Project Name:	Bishop Street Apartments		
Project ID:	2015-060		
Address:	72 Bishop Street	CBL:	293-C-002
Applicant:	Avesta 72 Bishop, LLC		
Planner:	Nell Donaldson

Bishop Street Apartments
72 Bishop Street
Level III Site Plan and Subdivision Review
2015-060
Avesta 72 Bishop Street, LP

Submitted to: Portland Planning Board
Date: July 10, 2015
Public Hearing Date: July 14, 2015

Drawing file: 5. Final Approved Plans and Documents / L2_Site Layout.pdf

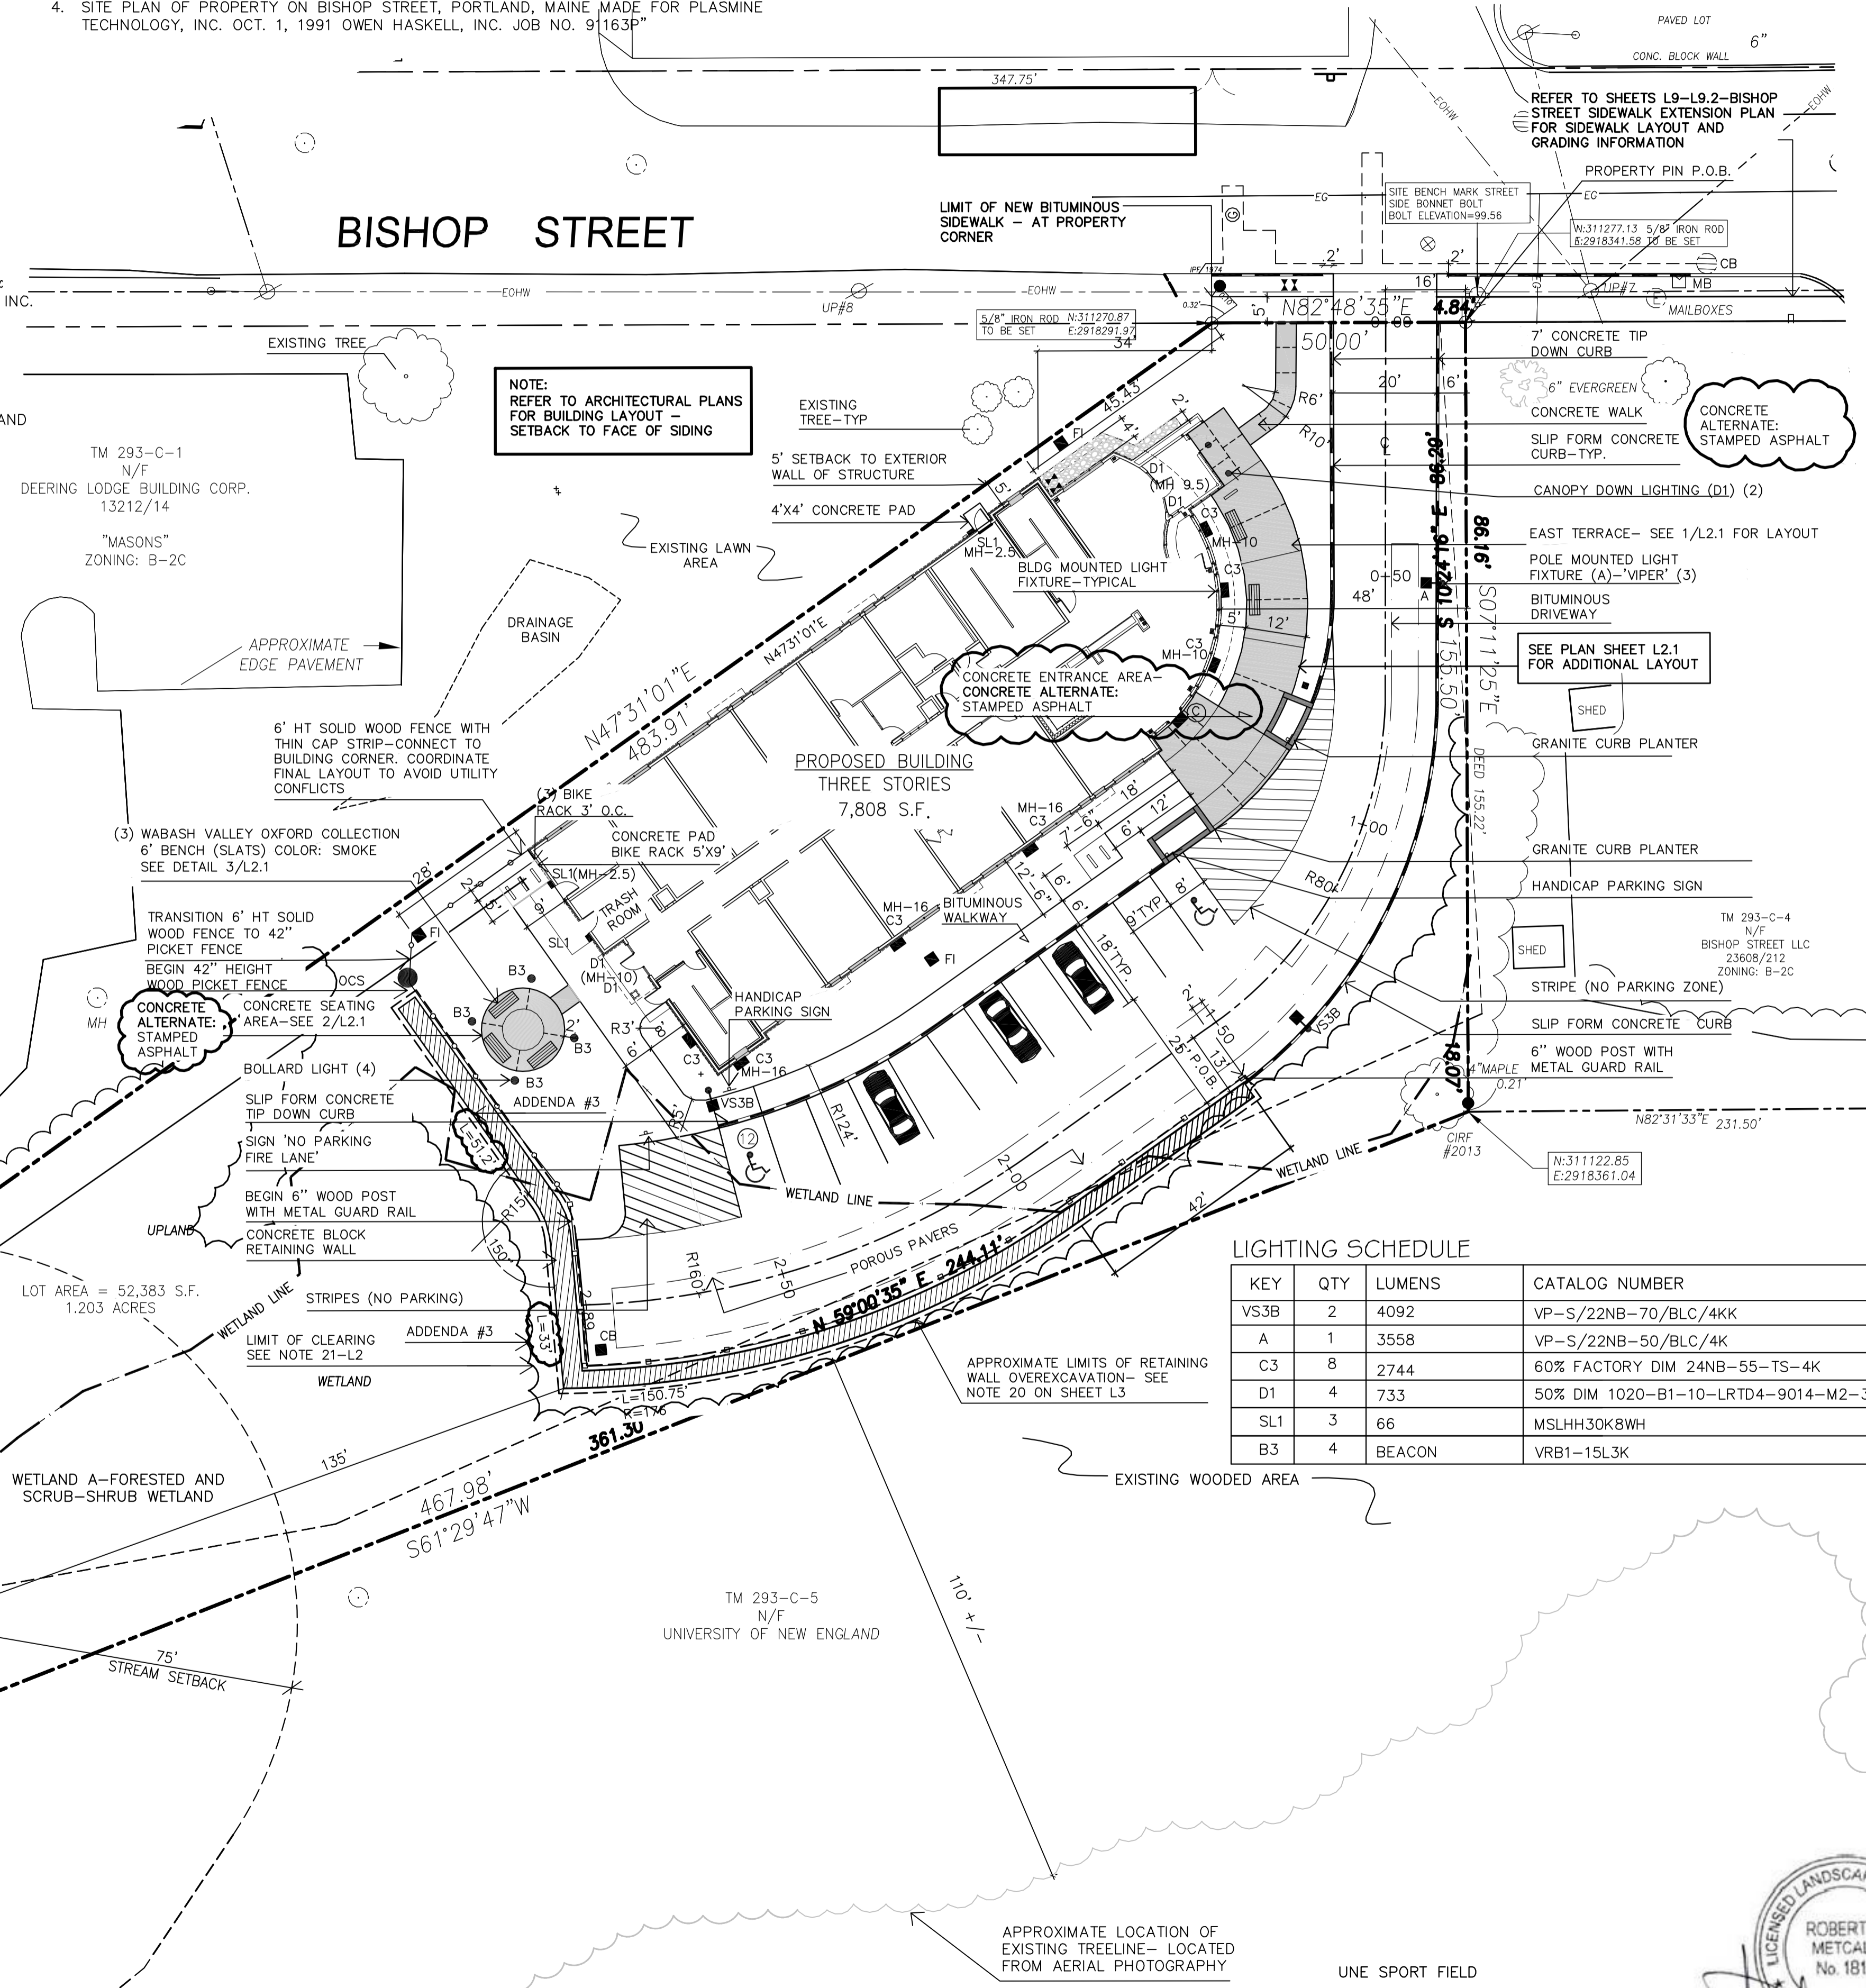
1. *Front Yard Maximum.* The B-2c zone establishes a front yard maximum of 10 feet, which the applicant continues to propose to exceed. At its closest point, the building is planned to sit 18 feet from the front property line (*Figure 5*). The ordinance does provide for an exception, stating that “the Planning Board or Planning Authority may approve a different amount for irregularly shaped lots or lots with frontage less than 40 feet provided this standard is met to the maximum extent practicable” (*Section 14-185*). The applicant has claimed in their site plan submittal that 72 Bishop is an irregularly shaped lot and that they have sited the building as close to the street as possible. The applicant writes,

The B-2 dimensional requirements also include a provision that, “[w]here setbacks exceed 10 feet, a continuous, attractive, and pedestrian-scaled edge treatment shall be constructed along the street, consisting of street trees spaced at no more than 15 feet on center, approved by city arborist, and a combination of landscaping no less than 4 feet deep, ornamental brick or stone walls or ornamental fencing” (*Section 14-185*). In the revised submittal, the applicant has added perennials/groundcover, hackberry and red maple trees, and azaleas and daphnes in the space between the building and the street line in an effort to provide sufficient edge treatment in this location (*Figure 5*). The arborist has reviewed the plans and generally found them satisfactory. The applicant is requesting that the board approve the project with the proposed deviation from the front yard maximum of the B-2c.

Title: SUBDIVISION PLAT PLAN

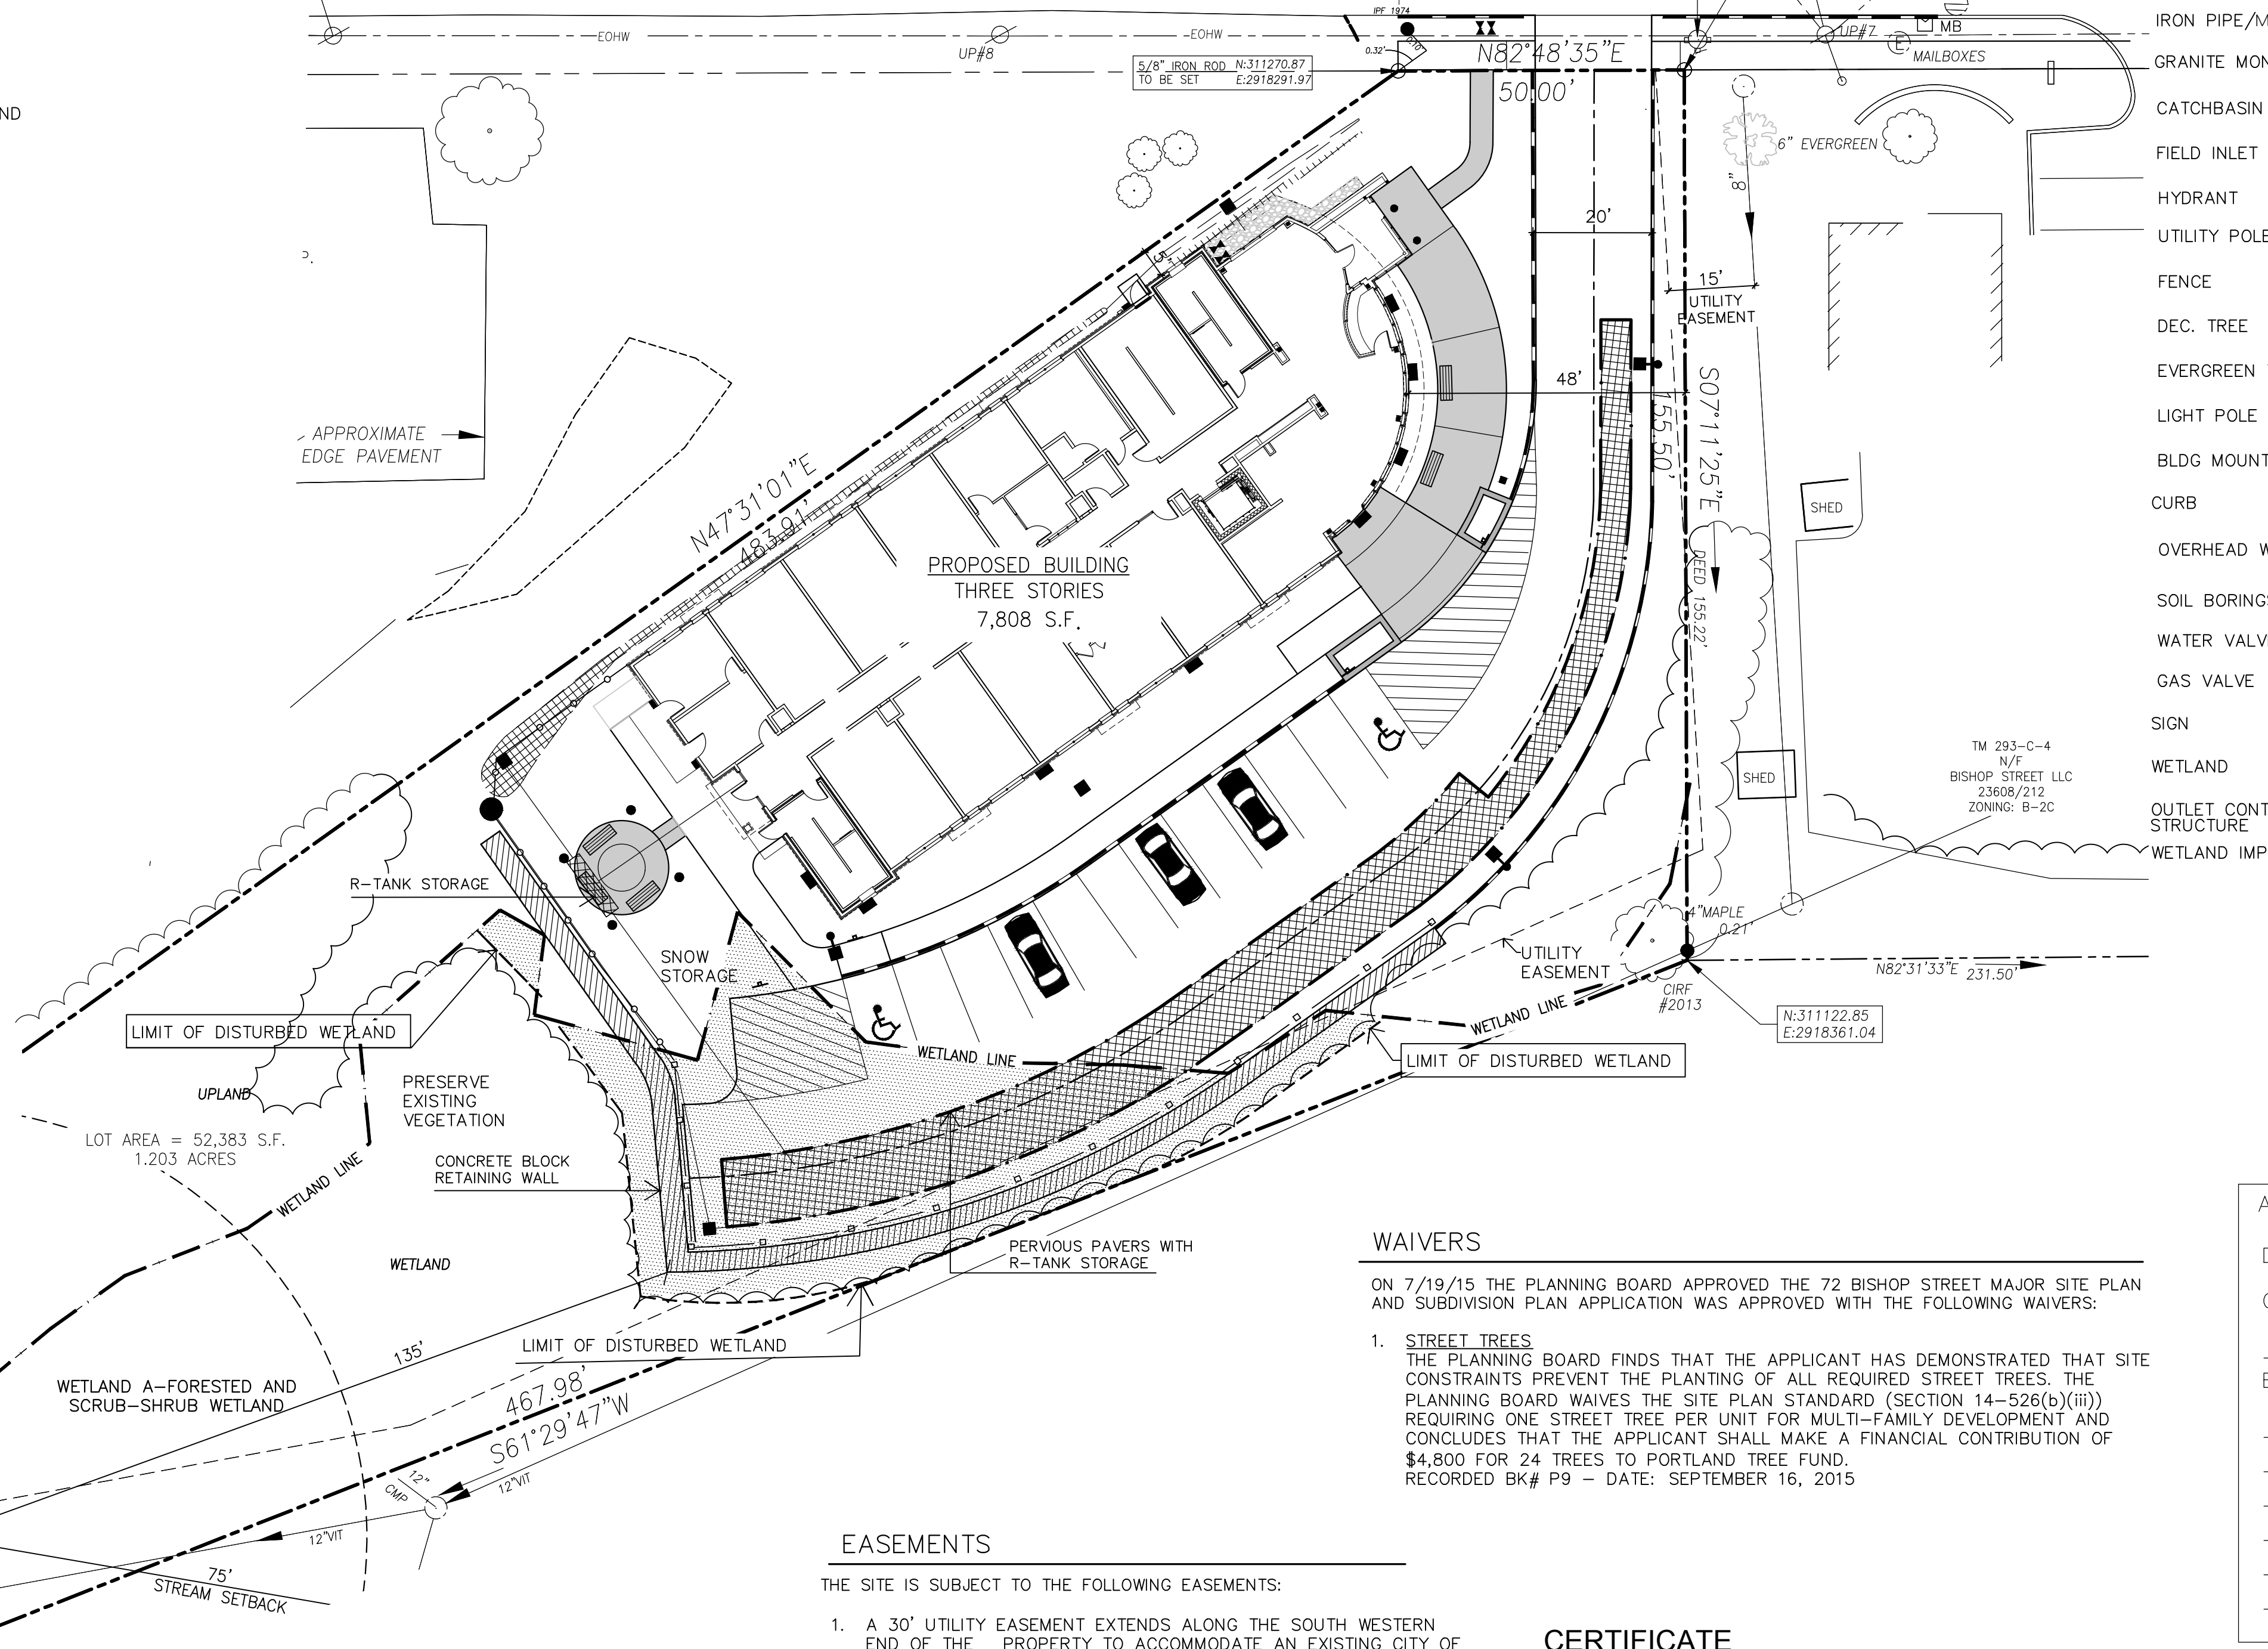
Mr. Clark, David Margolis-Pineo, of the city’s Department of Public Services, and Jen Thompson, Associate Corporation Counsel, have reviewed the draft subdivision plat and provided comments (*Attachments 2, 3, and 4*). The applicant has submitted a revised plat in an attempt to address these comments. Given additional changes which will be necessary following the planning board hearing, a final subdivision plat has been included as a condition of approval.

1. The applicant shall finalize the subdivision plat for review and approval by Corporation Counsel, the Department of Public Services, and the Planning Authority.
